Bolton by Bowland, Gisburn Forest & Sawley Parish Council
Higher Scarloom House,
Holden, Bolton by Bowland
Clitheroe
BB7 4PF

14 March 2023

Subject: Re: Holden Clough Nursery Planning Application 3/2022/0052

Please be advised that Bolton by Bowland, Gisburn Forest and Sawley Parish Council wishes to object to the above application.

Drawing file: planx_downloads / 22_0052_Proposed_Cafe_Plan_Rev_Ga_17Feb23.pdf

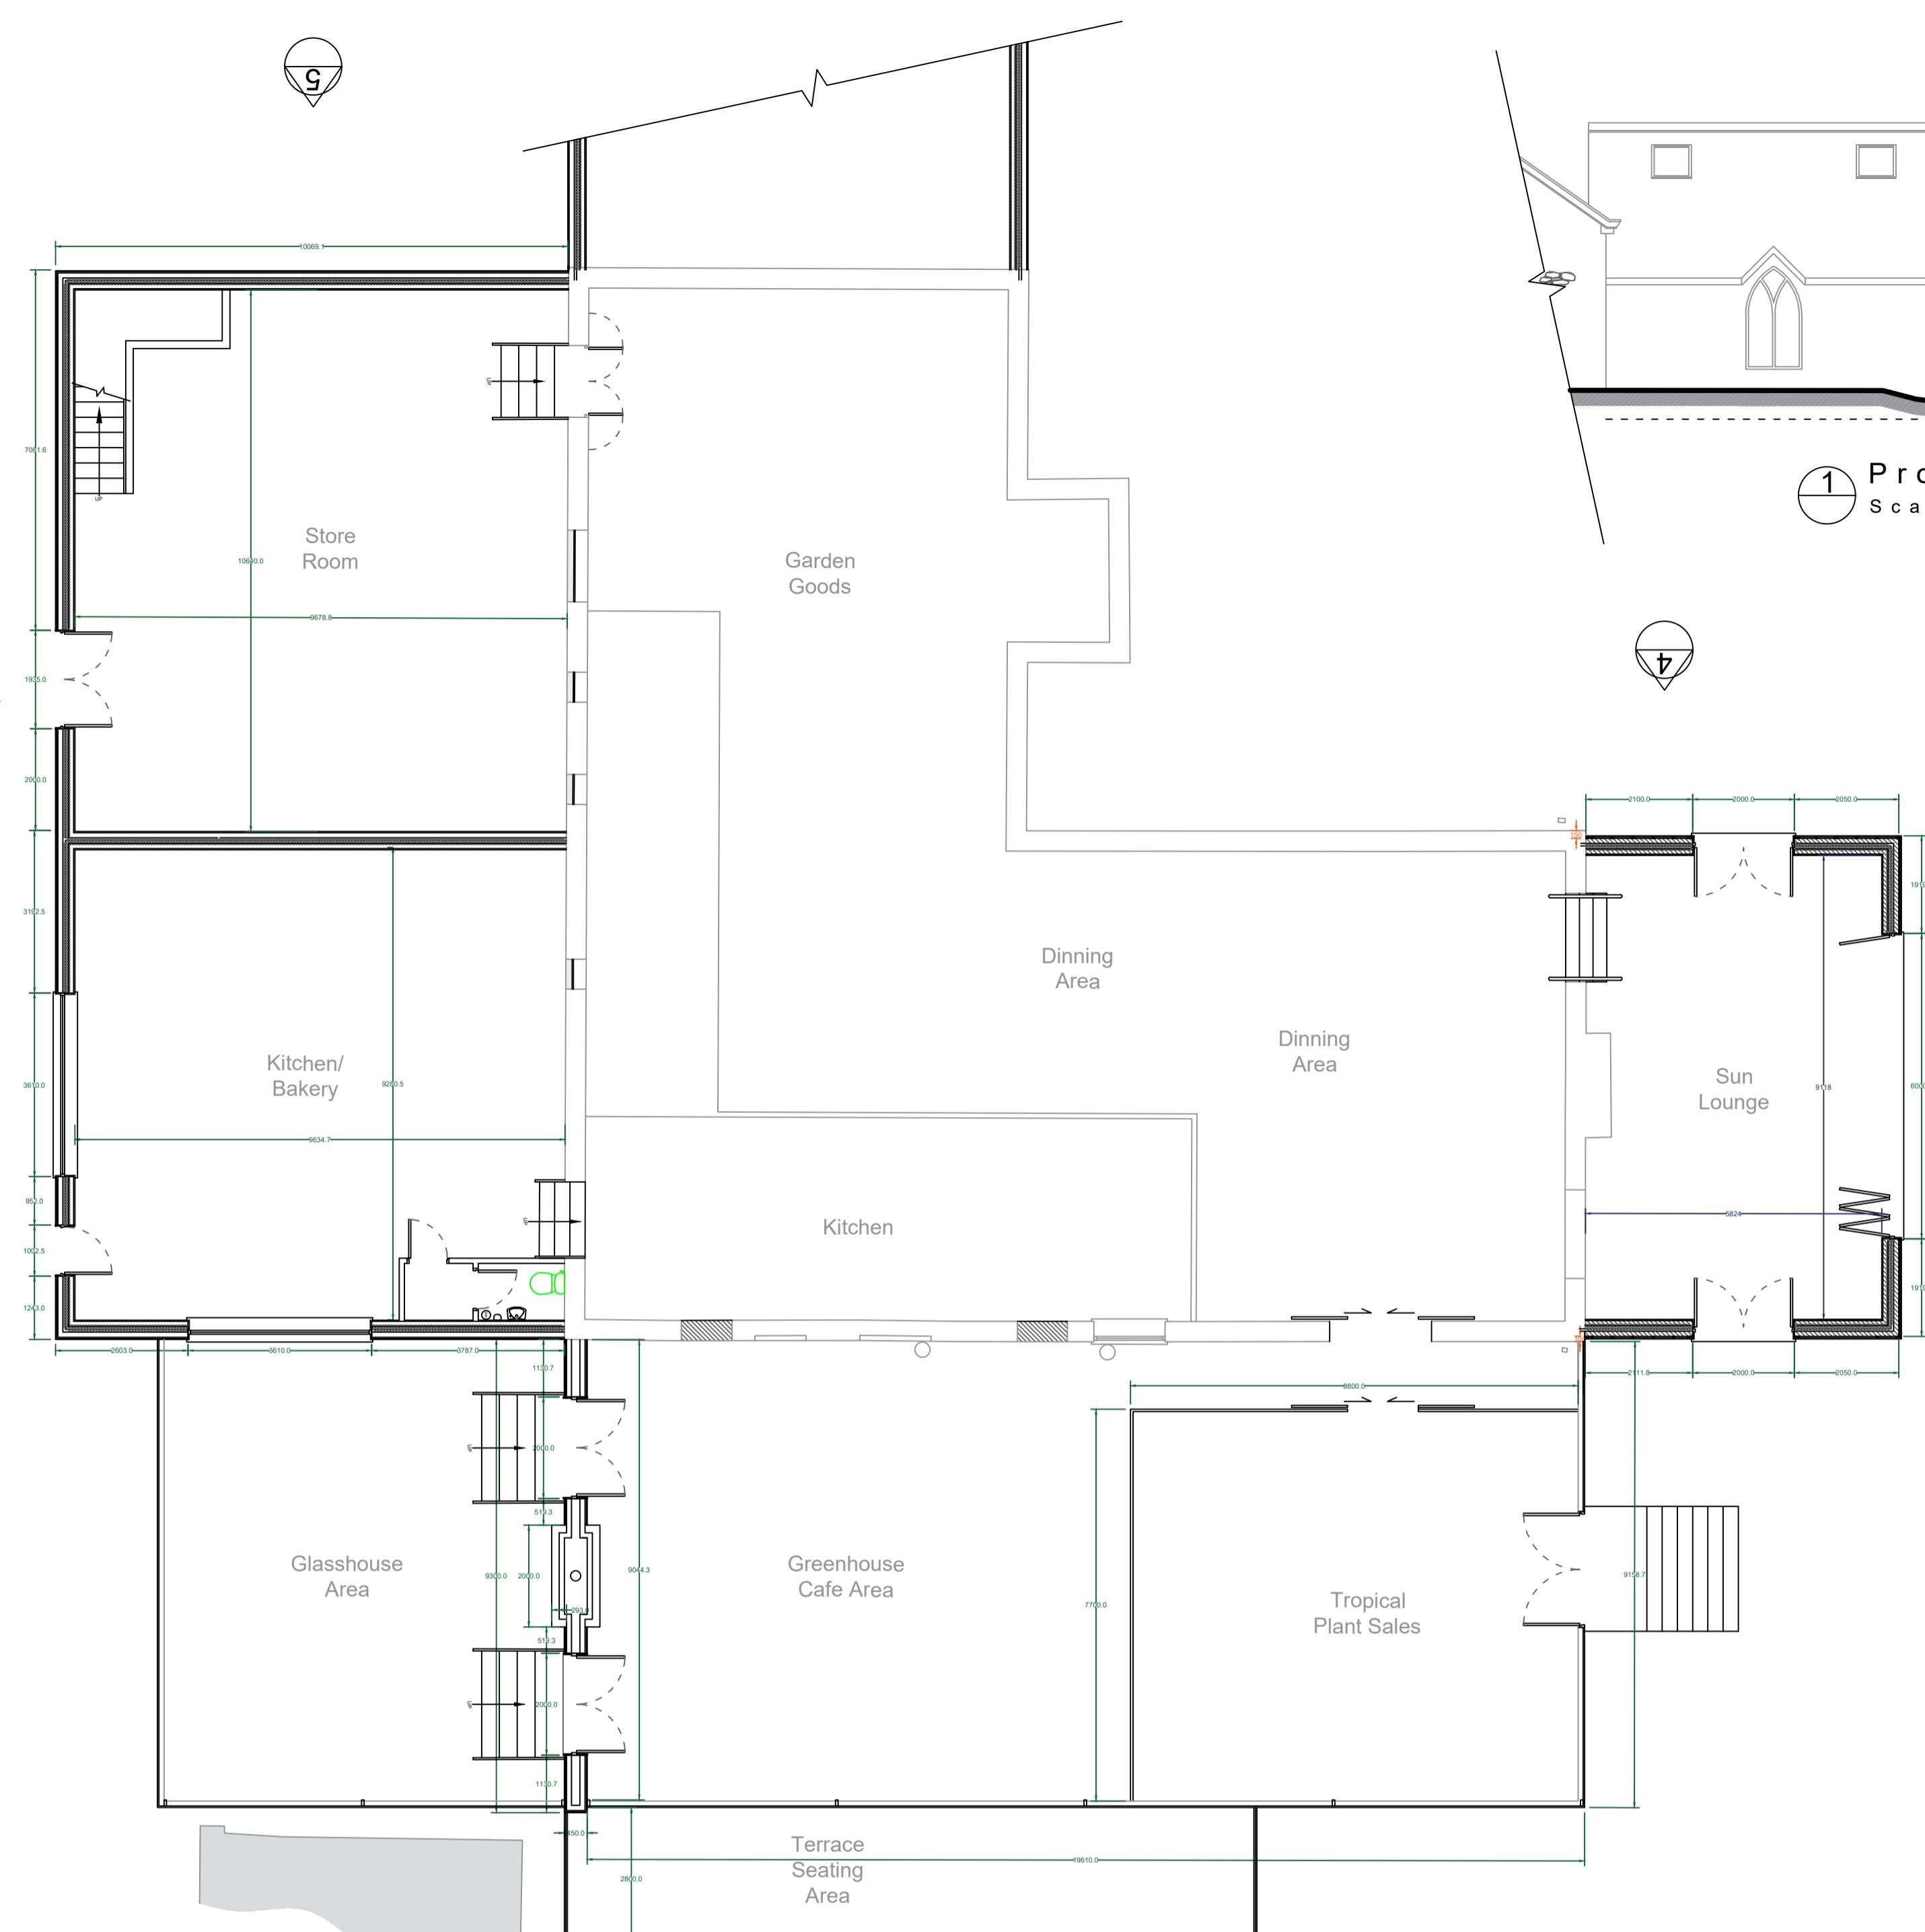
In the previously submitted application (3/2020/0602), the increase to the internal floor space was stated as being 354sq.m. And, in this resubmitted application (3/2022/0052), the internal floor space has reduced slightly to 345sq.m. Both approximate to a staggering increase of 80% of internal floor space. The applicant states that the proposal is "a relatively small extension" and has no intention of increasing the number of restaurants covers, which, quite honestly, does not make business sense.

In this application the Nursery is applying for retrospective planning permission for the structure built on at the rear of the original café. This didn't have planning permission and, although it was pointed out to LPA at the time it was being built, it was allowed to remain. In the new application, the Nursery is applying for retrospective approval of this

structure and permission to build a new structure along the eastern and southern sides of the Kitchen Garden.

Parish Council - The development will have a significant visual impact from both the Eastern and Northern sides of the existing site.

Parish Council - The terrace and Glasshouse extension will adversely impact upon neighbour amenity both in terms of visual impact, visitor intrusion and the noise levels form the open terrace to both the East and Northern boundaries of the site. This is contrary to Natural England’s “natural beauty criteria ”. The consistent flouting of previous permissions and environmental regulations should be considered by RVBC.
